Please see attached Galway County Council Planner's Report in relation to Substitute Consent Application ACP-324131-26 (Our Ref: SC02/26).

Planning Reference No.:	ACP-324131-26
Description of development:	Application for Substitute Consent pursuant to Section 177E of the Planning and Development Act 2000 (as amended) consisting of; Permission to retain refurbishment works to existing cottage which include for: (i) Front porch (ii) Revised elevations (iii) First floor extensions (iv) upgraded wastewater treatment system and (v) Ancillary site works and landscaping which include for the upgrading of existing vehicular entrance and driveway to the cottage (vi) A domestic pedestrian bridge over the existing stream and (vii) Steel container for storage purposes.
Location:	Ardagh Cottage, Clifden, Co. Galway H71KD34
Applicant(s):	Geraldine McGuinness and James O'Driscoll
Planning Area:	Galway West MD

FRONT ELEVATION  
SCALE 1:100

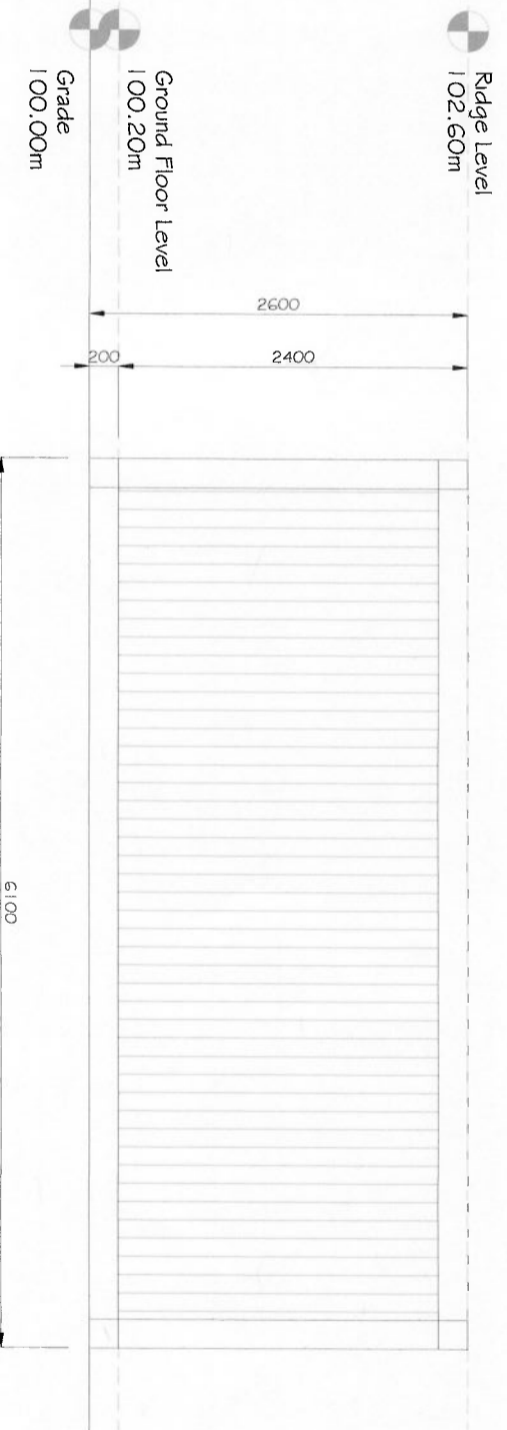
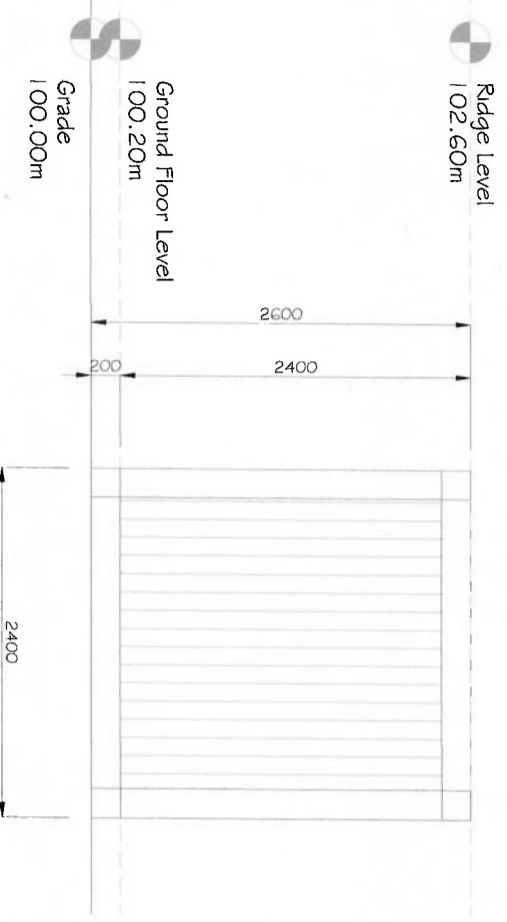
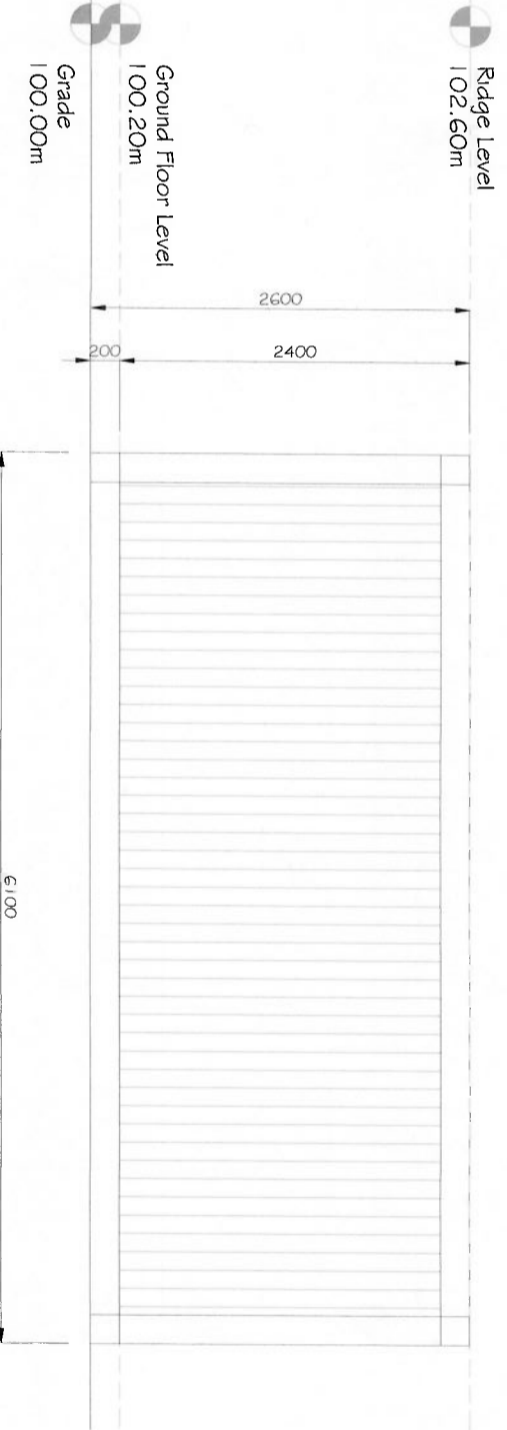
From review of available aerial photography and street view images, it is evident that the dwelling is substantially larger than the original cottage, and as result of the extensions and elevational changes carried out the works would not be considered to be subservient or in keeping with the character of the pre-existing dwelling. The Planning Authority refer An Coimisiún Pleanála to DM standard 4 of the Galway County Development Plan 2022-2028.

CONTAINER SHED FLOOR PLAN  
SCALE 1:100

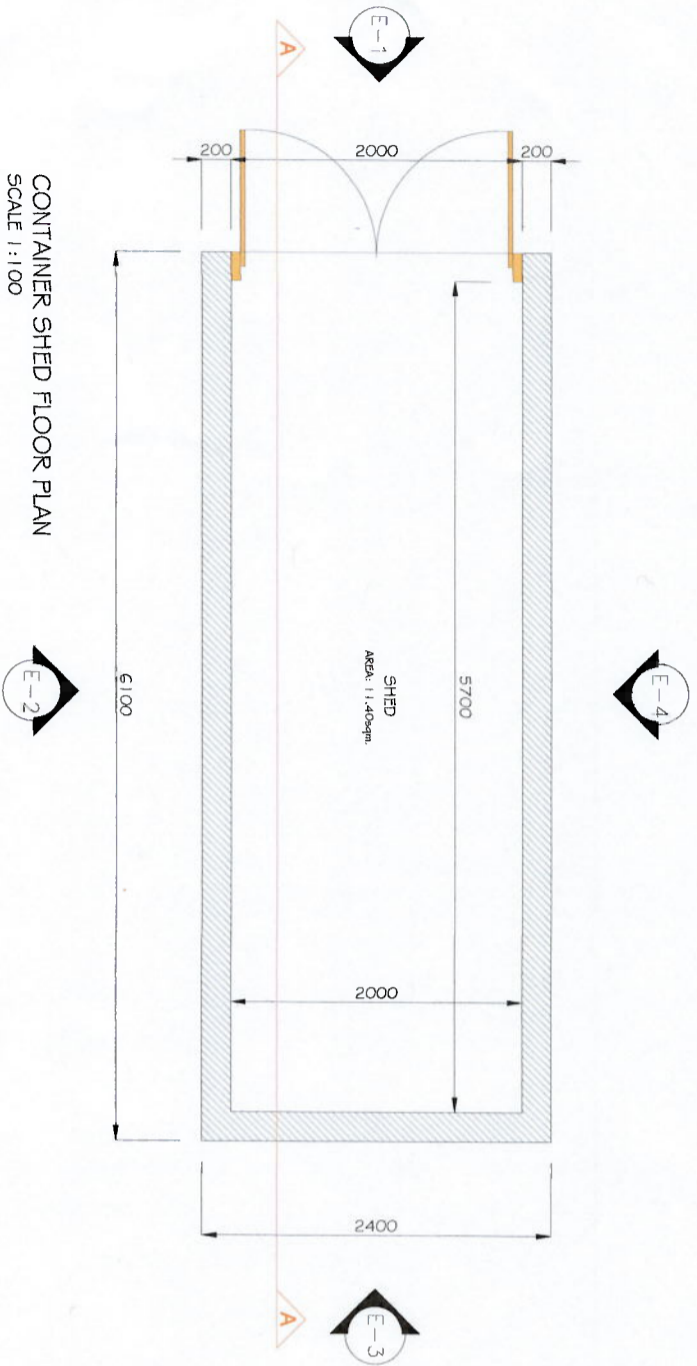
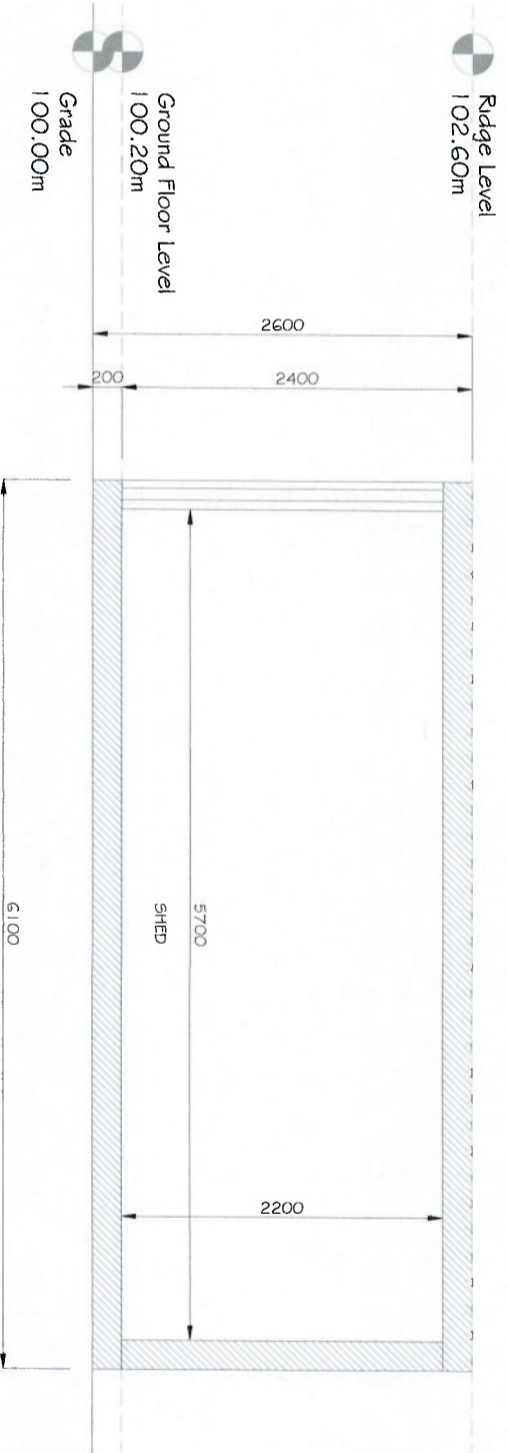
The Planning Authority would not welcome the retention of the steel container on site, having regard to its siting to the front of the property, in addition to the design, form and materiality which is not ancillary or consistent with the main dwelling house on site. The steel container materially contravenes DM standard 6 of the Galway County Development Plan 2022 -2028.

Figure 3.2. Site plan of property with measured distances of wastewater treatment facility to river.

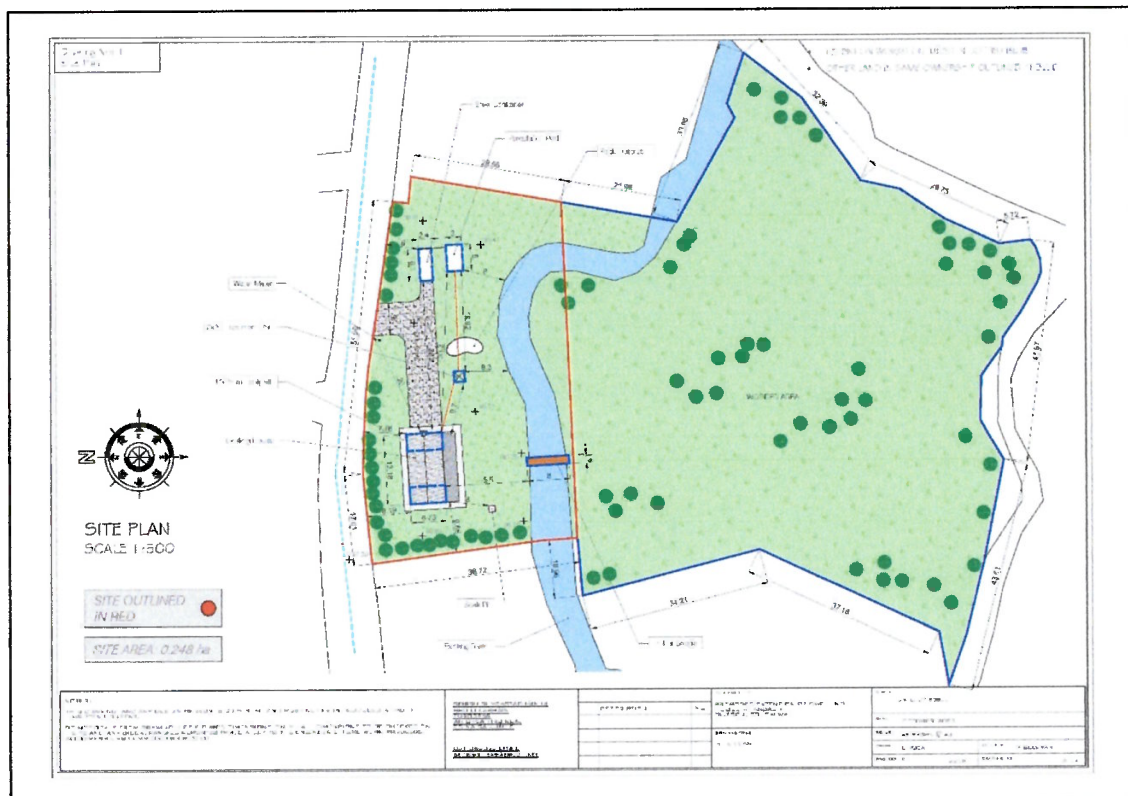
Having reviewed the application documentation, the Planning Authority note the appendices to the rNIS in respect of the WWTS proposed to be retained. Furthermore, the Planning Authority note the discrepancies and concerns raised in the Onsite Waste Water Treatment System Inspection Report following an inspection in February 2022, notably sections 8.2 – 8.12. There are no documents on file addressing the discrepancies and concerns. An Coimisiún Pleanála should ensure the safe disposal of domestic effluent on site in strict accordance with the EPA 2021 Code of Practice Domestic Waste Water Treatment Systems (Population Equivalent ≤ 10) can be achieved and rule out that to grant the proposed development to be retained would not be prejudicial to public health, would not be contrary to the EPA Code of Practice manual and to Policy Objective WW6 of the Galway County Development Plan 2022-2028.

5. (a) The existing septic tank and percolation system shall be maintained and operated in good working order at all times to best practice standards.
(b) The septic tank shall be regularly de-sludged to ensure the septic tank functions properly and prevents pollution.
(c) The recommendations as set out in Section 5.5 rNIS received by the by An Coimisiún Pleanála, shall be implemented in full.
(d) The applicant shall maintain a documented record of all inspections and maintenance undertaken by an appropriately trained and qualified person.
